HANNAH RIDGE AT FEATHERGRASS FILING NO. 5

A REPLAT OF TRACTS HH AND JJ OF HANNAH RIDGE AT FEATHERGRASS FILING NO. 1 RECORDED UNDER RECEPTION NO. 214713468, RECORDS OF EL PASO COUNTY, COLORADO BEING A PORTION OF SECTION 32, TOWNSHIP 13 SOUTH, RANGE 65 WEST OF THE SIXTH PRINCIPAL MERIDIAN, EL PASO COUNTY, COLORADO

SF-18-038

Subject: text box
Page Label: 1
Author: Steve Kuehster
Date: 11/19/2018 10:36:47 AM
Color: ■

HANNAH RIDGE AT FEATHERGRASS
FILING NO. 5
JOB NO. 1116.05
OCTOBER 4, 2018
SHEET 2 OF 3

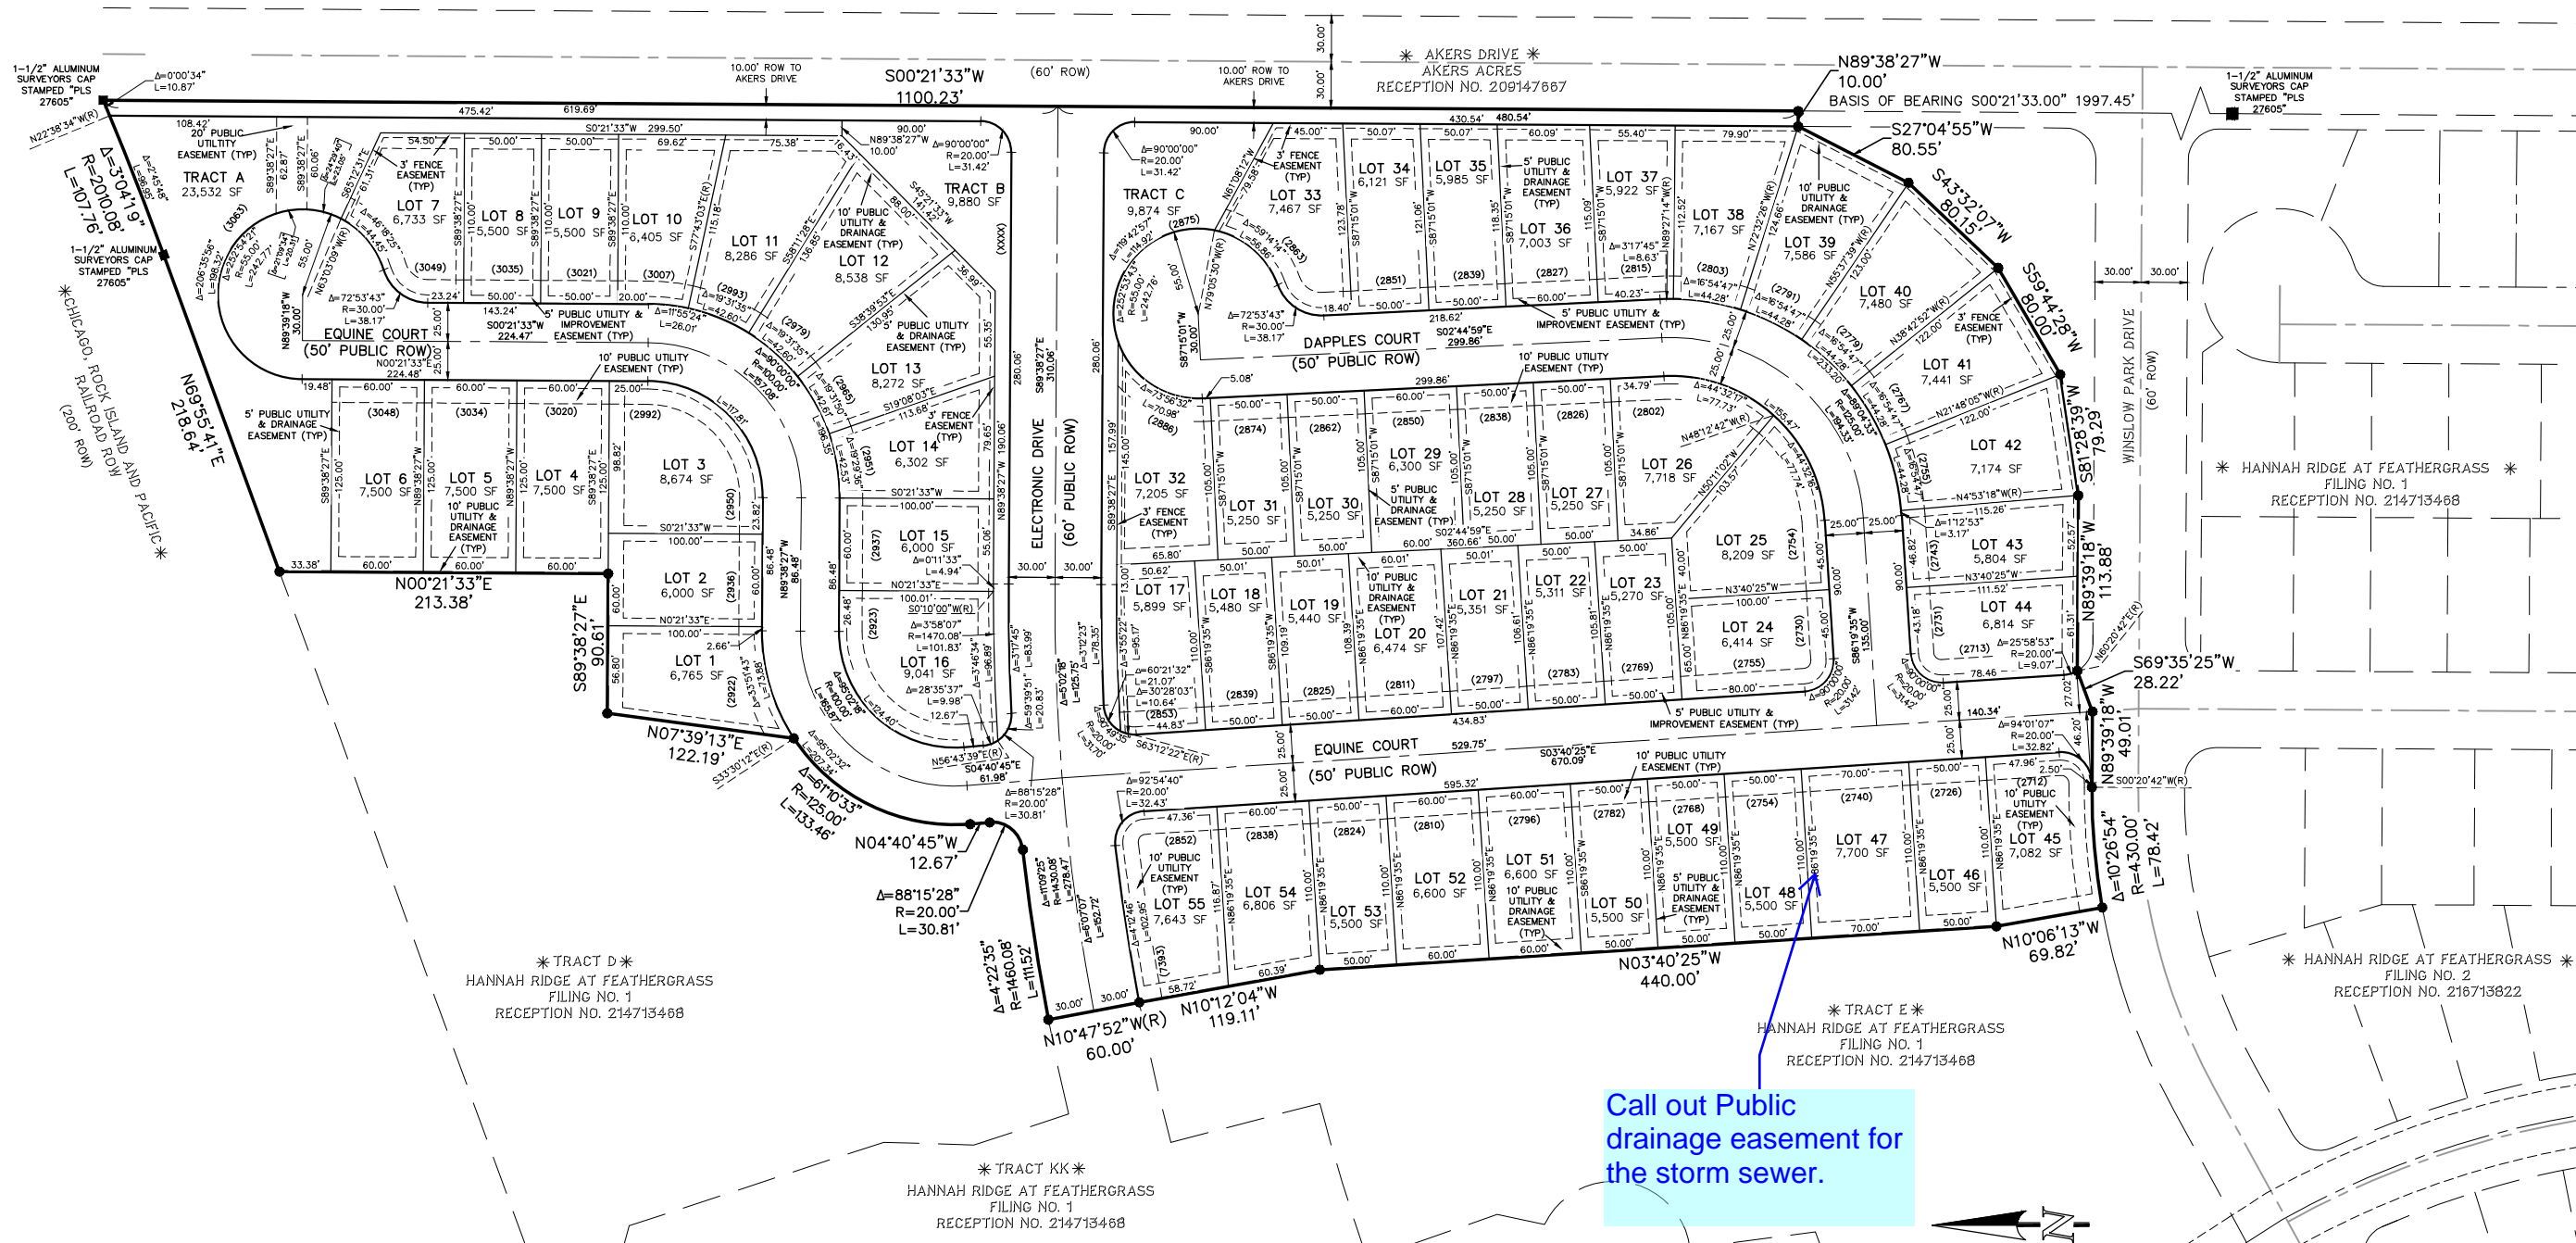
define the outer subdivision line boundary with a thicker or different line type. It is difficult to see what is being replatted

Call out Public Drainage easement.

Call out Public Drainage easement.

define the outer subdivision line boundary with a thicker or different line type. It is difficult to see what is being replatted
